Deadline 5: ERYC Actions & Response

The Examining Authority's written questions and requests for information (ExQ2)

ERYC Response

**Drawing Name:**  
Information Plan

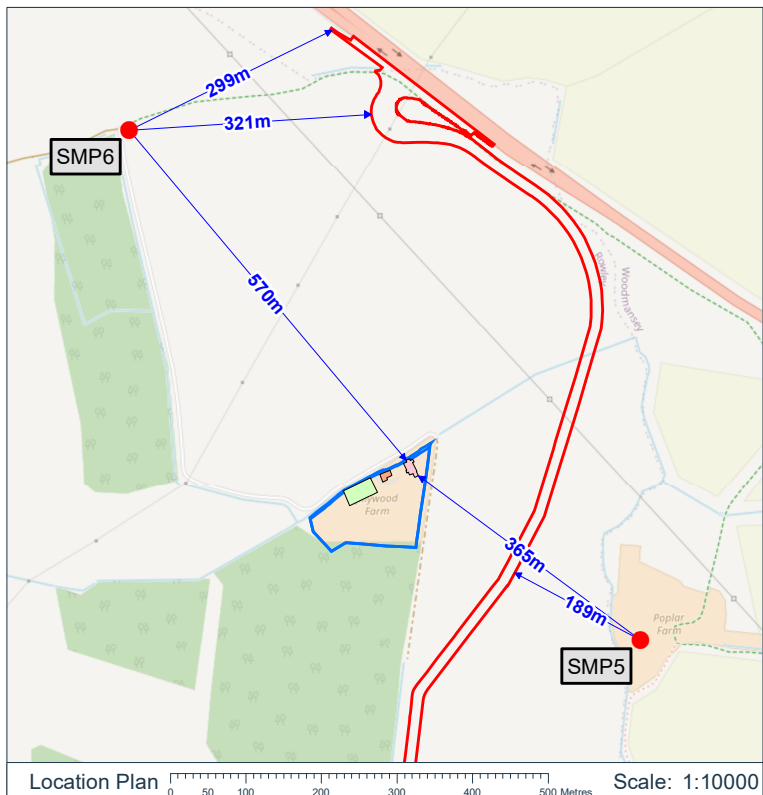
TT.2.4 – Correct. Condition 22 attached to planning permission reference 20/01073/STPLF states:

No development shall take place on site until access details to private properties known as Platwood Farm, Mouse Hill, Jillywood Farm, Rose Villa, Bentley Lodge, Spring Mount and Bramble Hill Farm have been submitted to and agreed in writing with the Local Planning Authority.

This pre-commencement condition is imposed in accordance with policy ENV1 of the East Riding Local Plan and to allow safe access and egress to each named private property.

Applicant has not applied to discharge this condition at the present time but should be submitted and agreed by end of June 2023.

Satisfied with data submitted.
